RE: CU-23-0001 3 Boots Custom Cuts

It is with deep concern I write to you regarding the proposed meat processing facility, 3 Boots Custom Cuts, south of my property at 3200 Wilson Creek Road. Below are my concerns.

Drawing file: CU-23-00001 3 BR Custom Cuts / CU-23-00001 3 BR Custom Cuts Site Plan.pdf

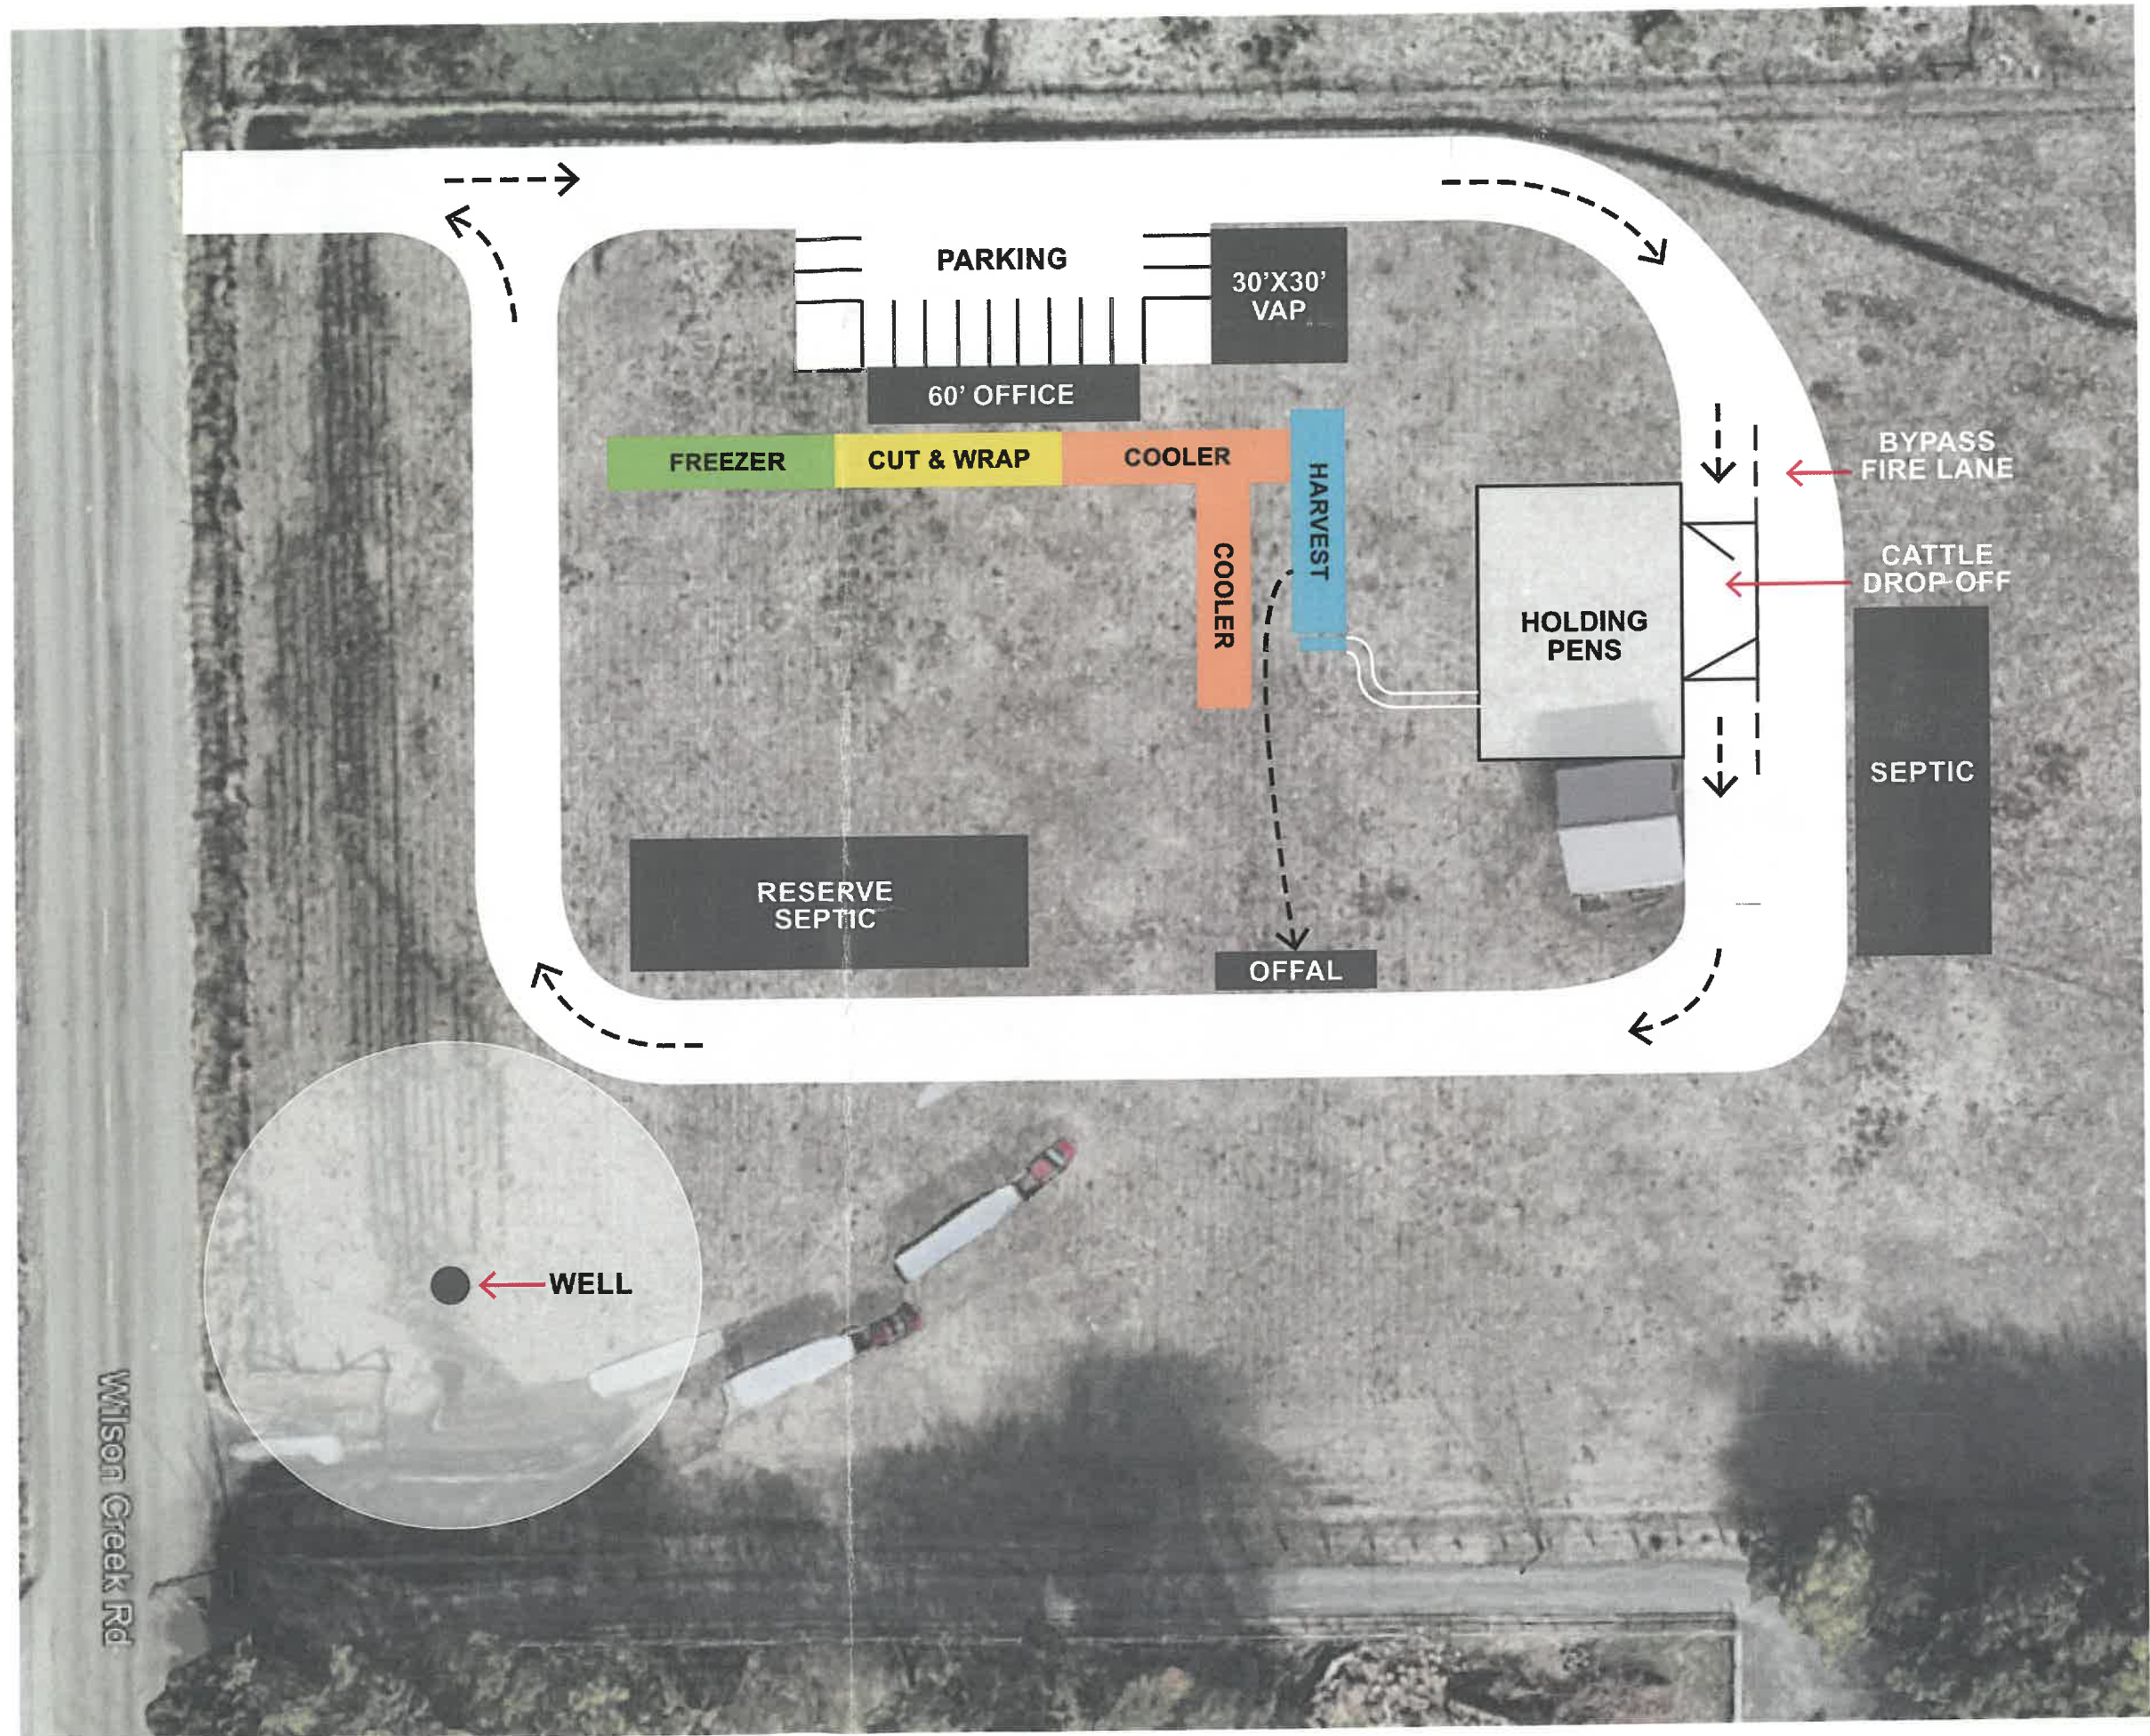
- Insufficient/contradictory information -Wastewater disposal and septic system. The contractor’s narrative indicates “a standard septic system”. However, the site map clearly shows one septic and one reserve septic. The SEPA report also indicates “...occasion wash downs for cleaning the facility. All water used will go into standard approved septic systems.” What is being done with the blood and fat residue? If that is hauled out, how do you collect all of it and prevent any from going into the septic system? Waste of this type will not break down in a septic system and would create an environmental health hazard. It is not clear how wastewater from the processing and cleaning will be disposed of.
